21 November 2016

Our Ref: 2016/606506
File No: R/2014/17/E

**SSD 5824 MOD 2 – One Carrington Street – Section 96(1A) Modification
Application to include stratum subdivision to the proposal**

LOCATION PLAN

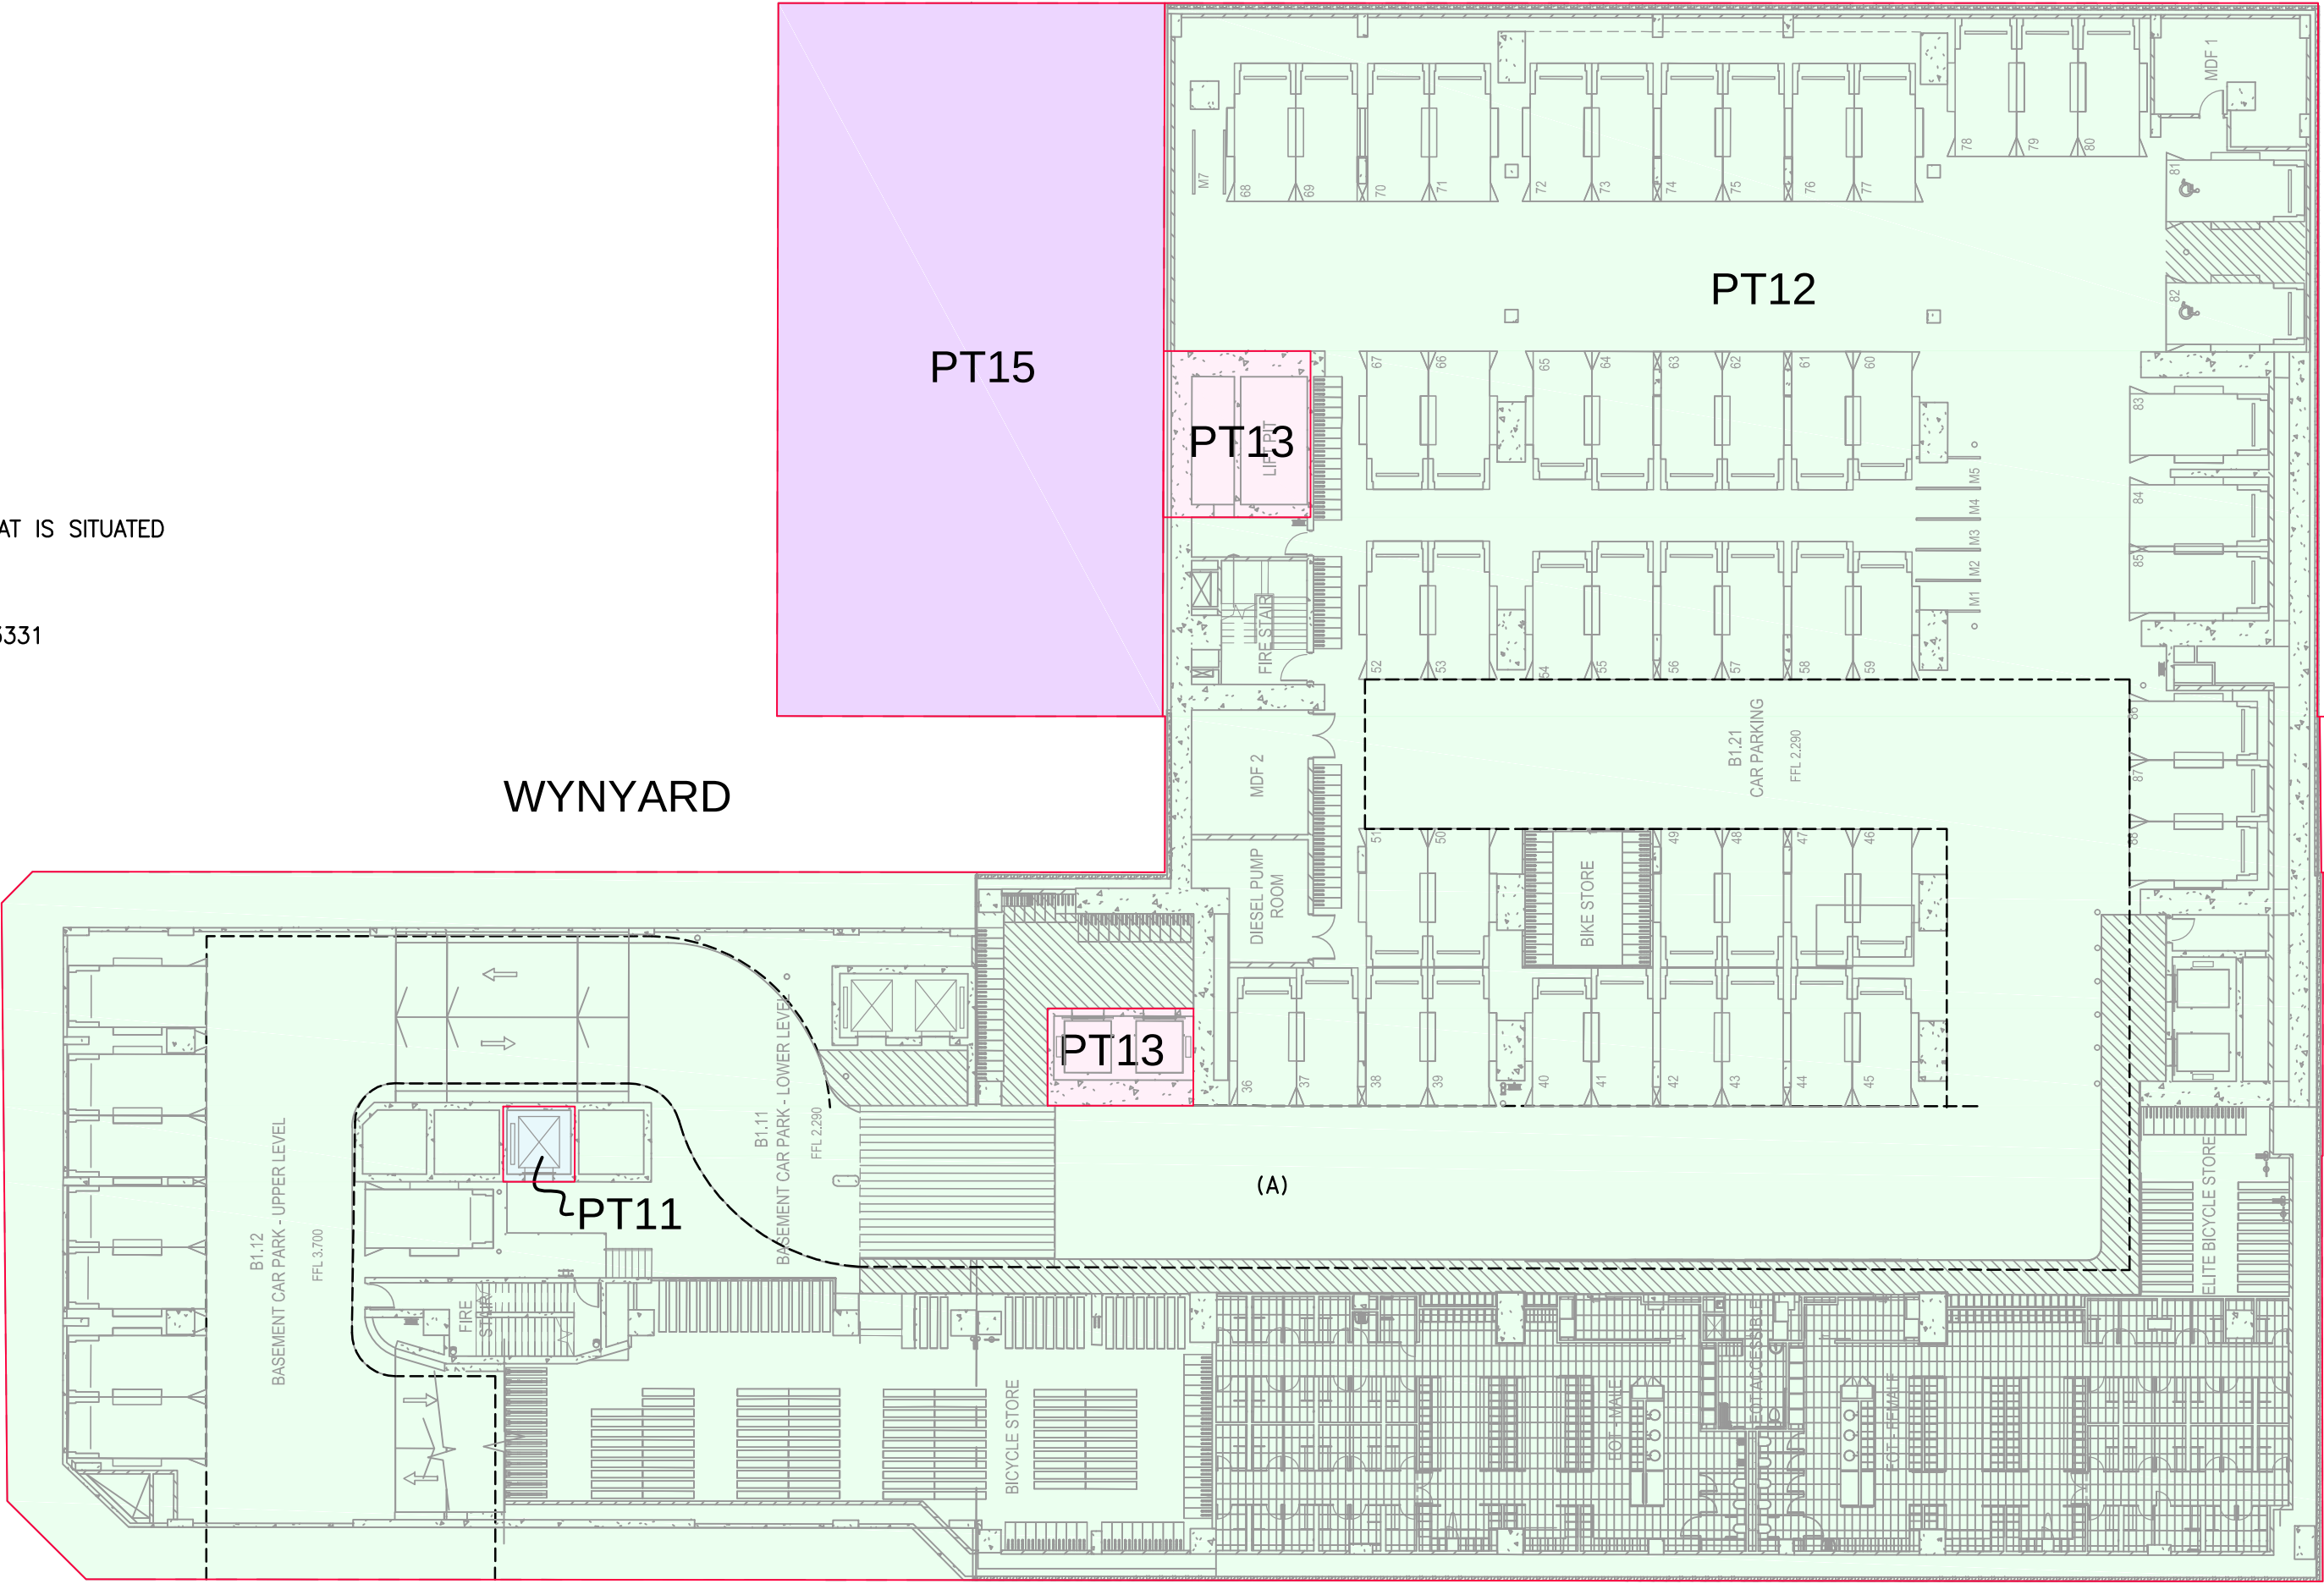
1. Inconsistencies between the proposed subdivision plans and approved floor plans have been resolved with the amended plans.
2. Notwithstanding the plan inconsistencies being amended, the Brookfield Submission does not adequately address the matters raised by the City.
3. The City does not agree with Brookfield's statement that subdivision for lease purposes is not possible under the Conveyancing Act. A plan of subdivision for lease purposes is possible and in this case preferred.
4. The City **objects** to the proposed subdivision plan for the proposed stratum above Wynyard Lane. This objection would be immediately withdrawn by the

City if the subdivision plans are amended so as to identify a subdivision for lease purposes.
